Demolition of 1 No. existing house & grounds & erection of 2 No. new detached dwellings. This application may affect the character & appearance of the Station Road, East Preston Conservation Area.

St Marys Close Hurst Road Rustington

Thank you for your internet representation made on 7th October 2018 which has been recorded as '**an objection**' with the comments as follows:

Drawing Title:
ADDITIONAL DWELLINGS
BLOCK/ SITE PLAN

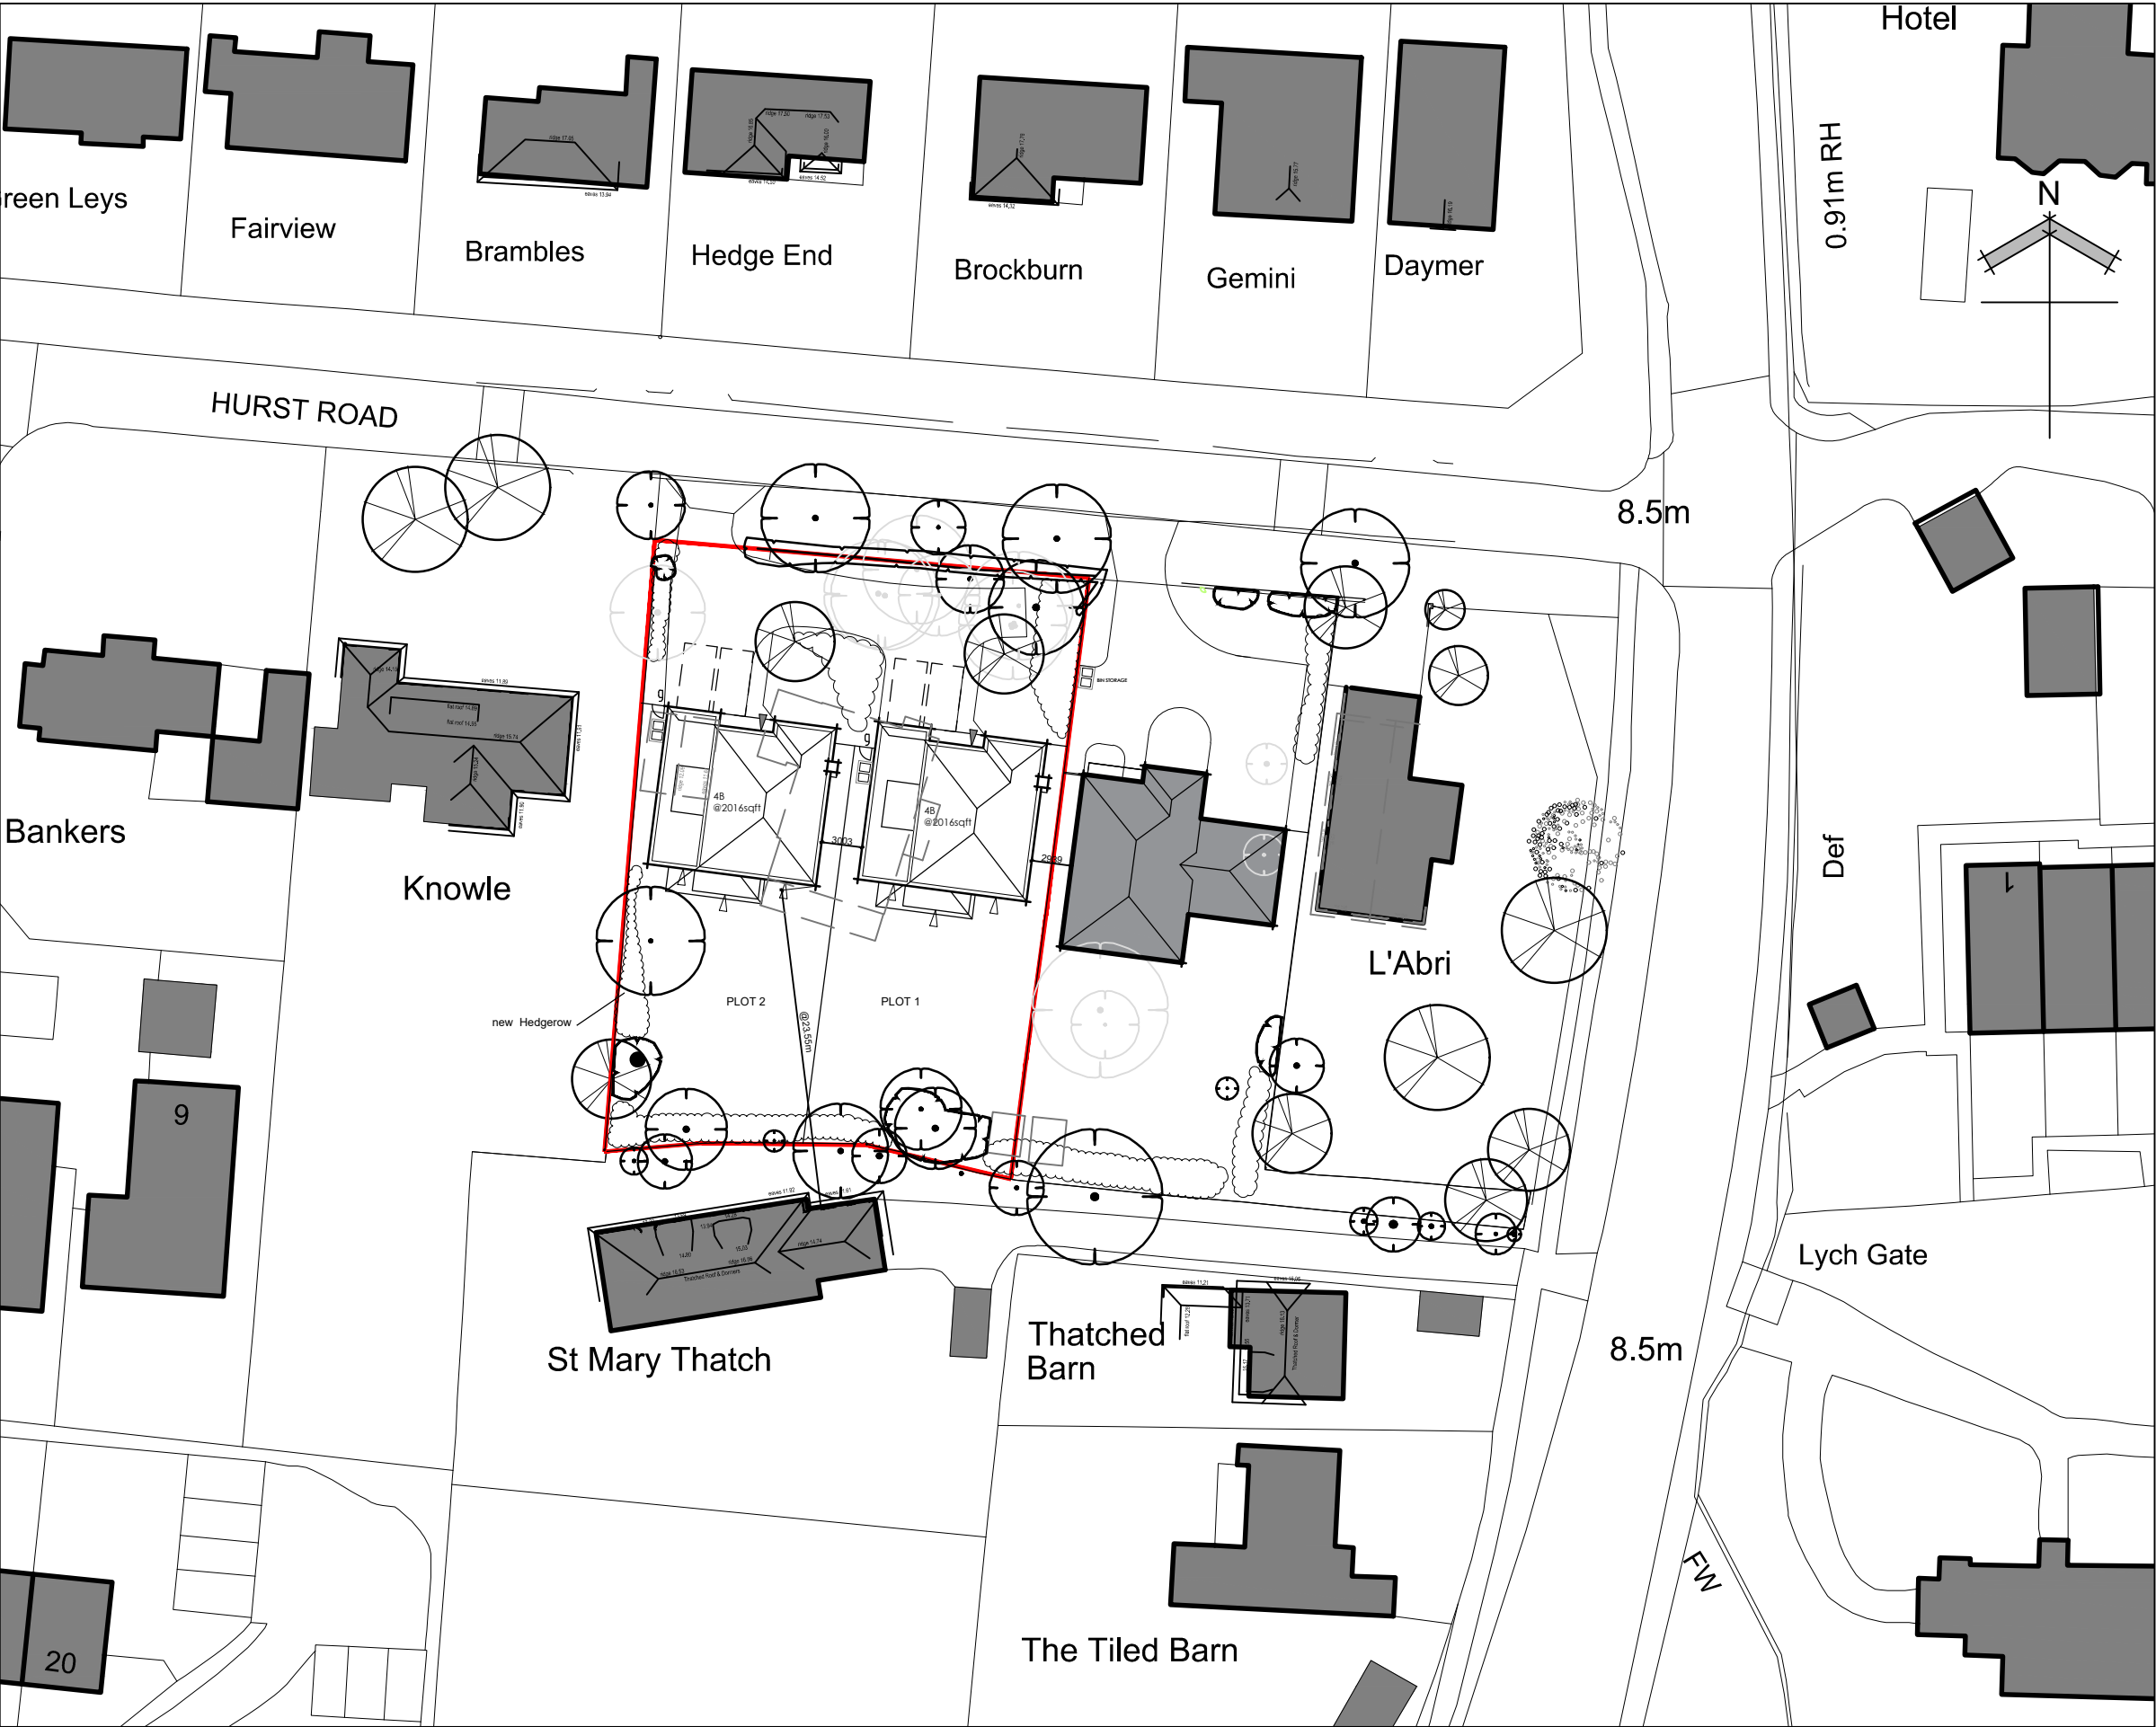
The planned development concerns me for two principle reasons. 1. the plan is for two identical properties adjacent to each other. This is out of character with the rest of Hurst Road and would set a dangerous precedent for the future of the road. Additionally, the style of development appears to be of the same 'look' as the planned development of a single adjacent property under a different application giving the appearance of homogenous development across a large stretch of a currently heterogenous road. 2. The plans suggest a single shared driveway. This is out of character of the rest of the road where each property has its own, uncontested driveway. Given the local residents agreement to no on-street parking, this shared driveway offers the potential for future disagreement between the users of the shared driveway causing on street parking overflow issues. Additionally the drawings do not make specific allowance for the positioning of the existing trees in the road; a road featuring a regularly spaced tree lining that forms part of it's character. The plans should take this into consideration and give residents confident that the street scene will not suffer through this development.
